SP234

**EL PASO COUNTY
 GRADING AND EROSION CONTROL PLAN CHECKLIST**

SHEET **2** OF **7**

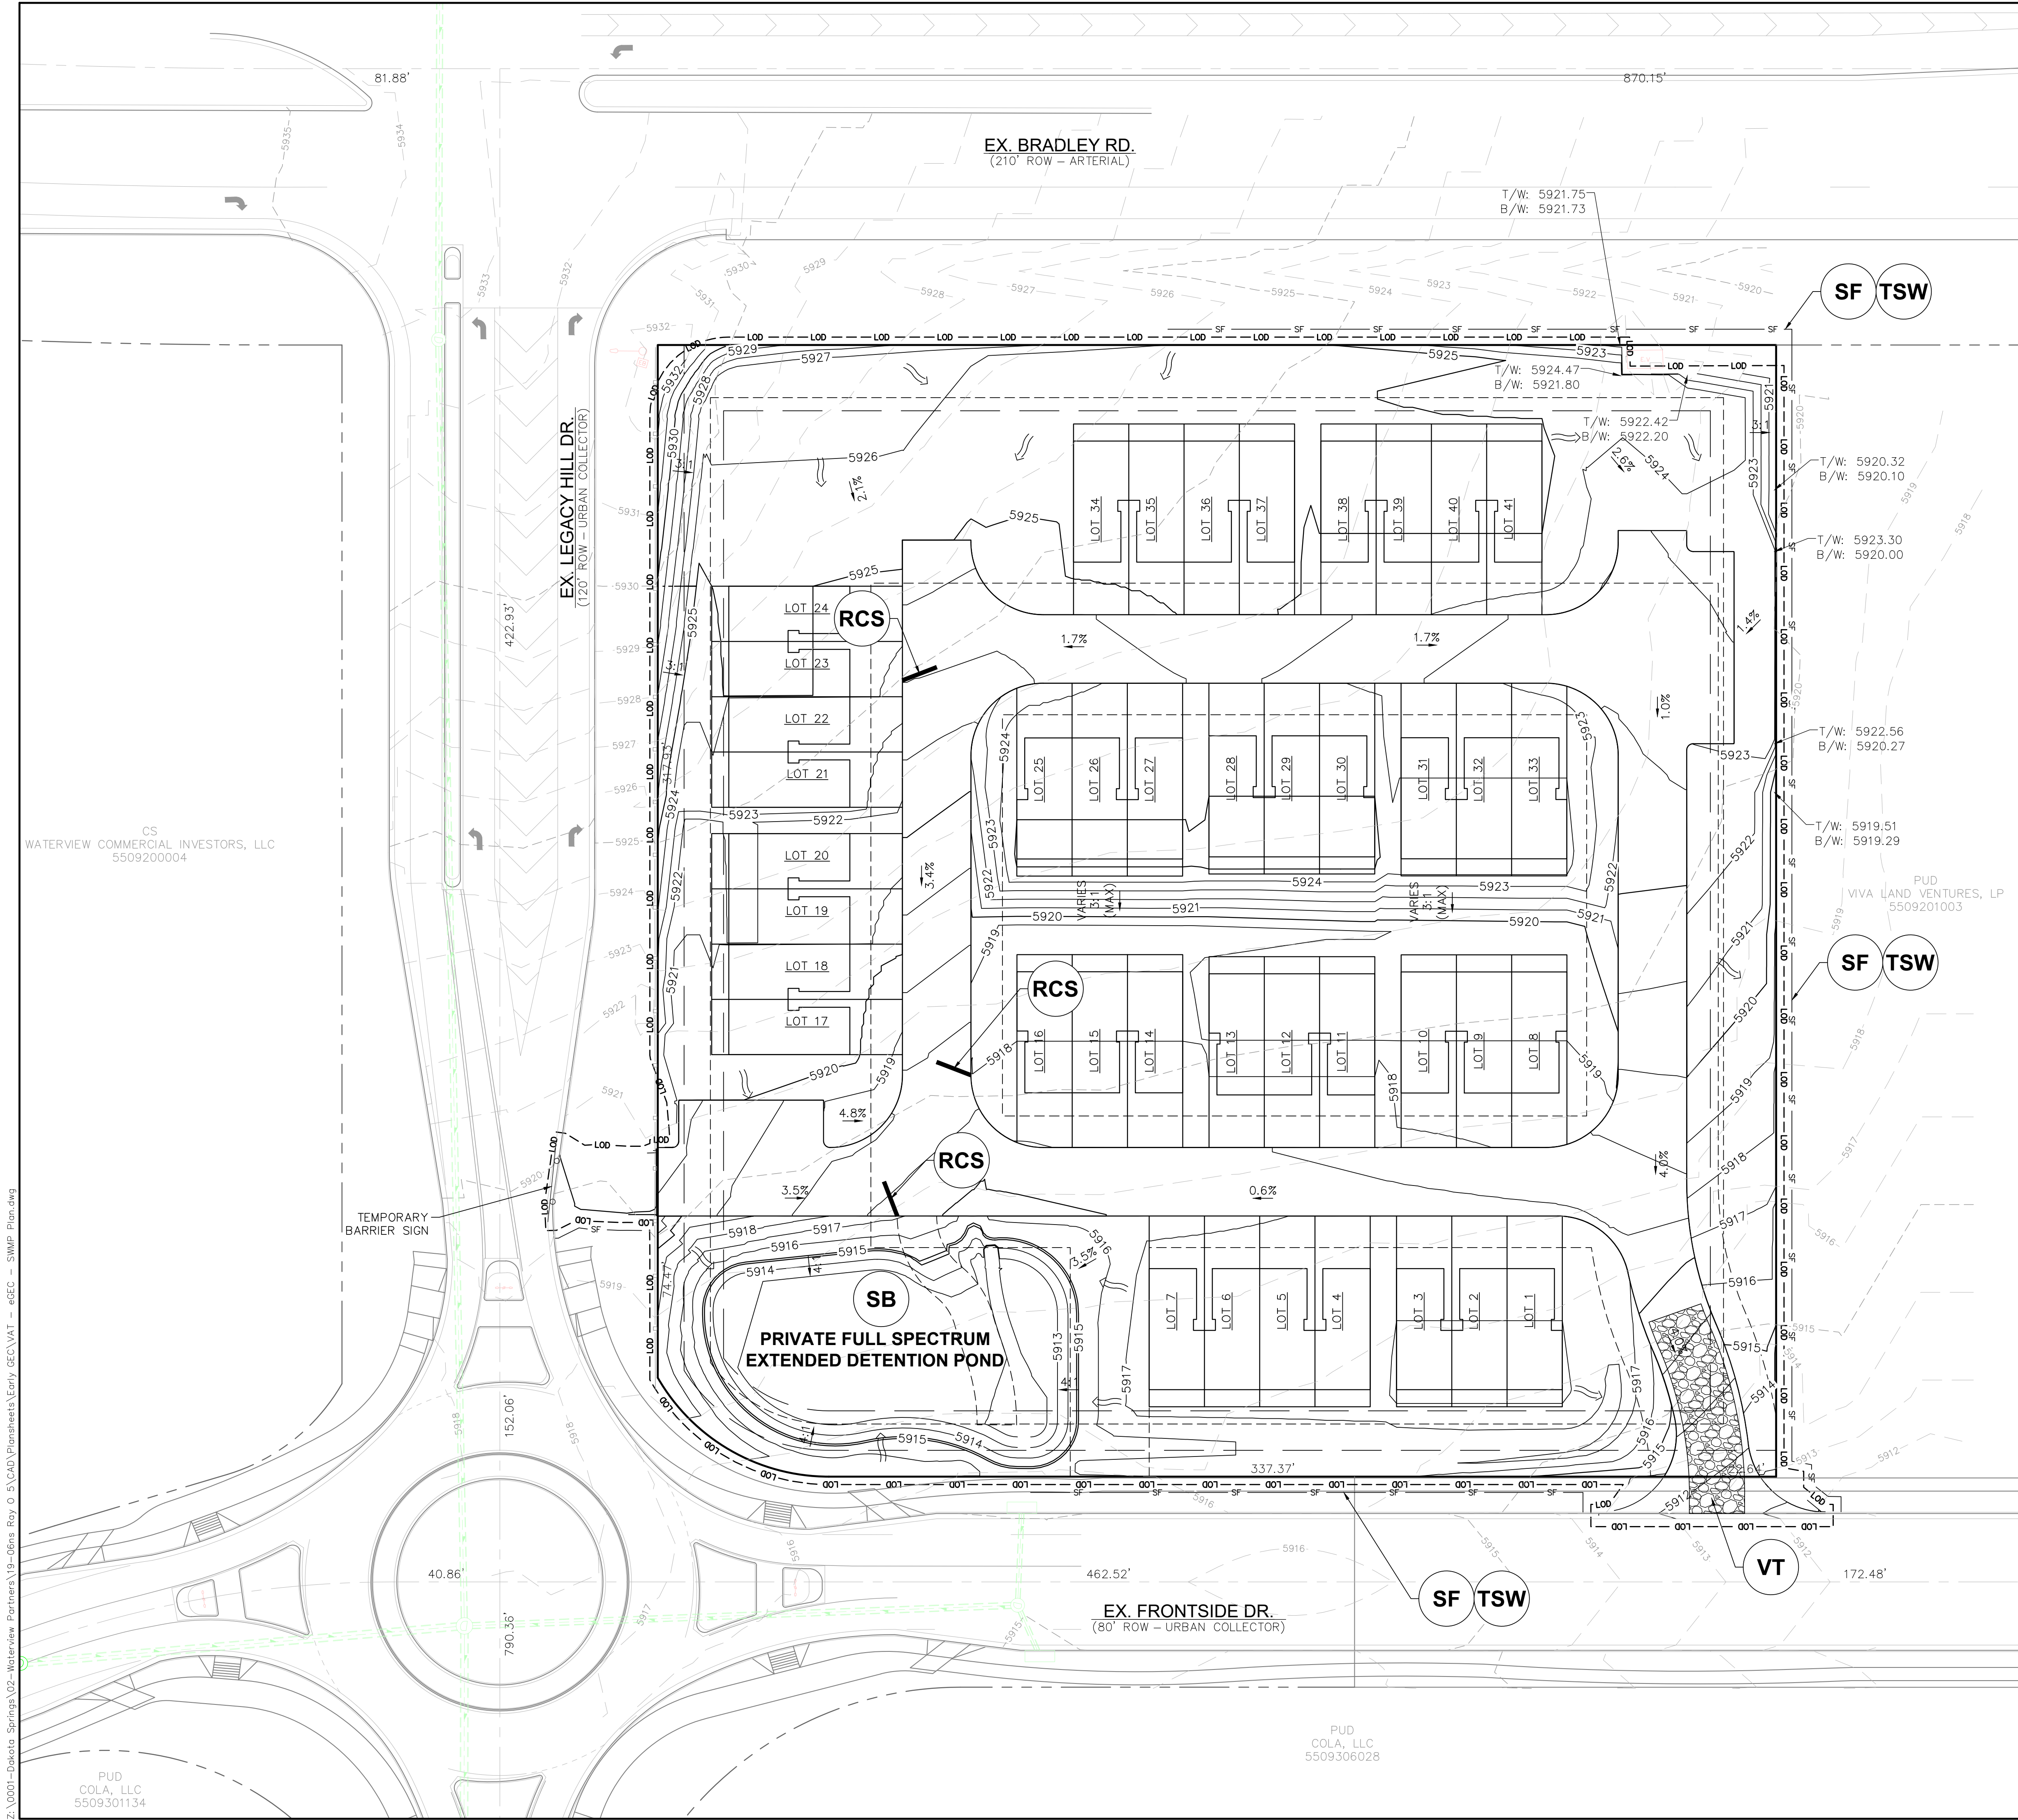
Revise notes on Sheet 2 of planset to match all of these notes.
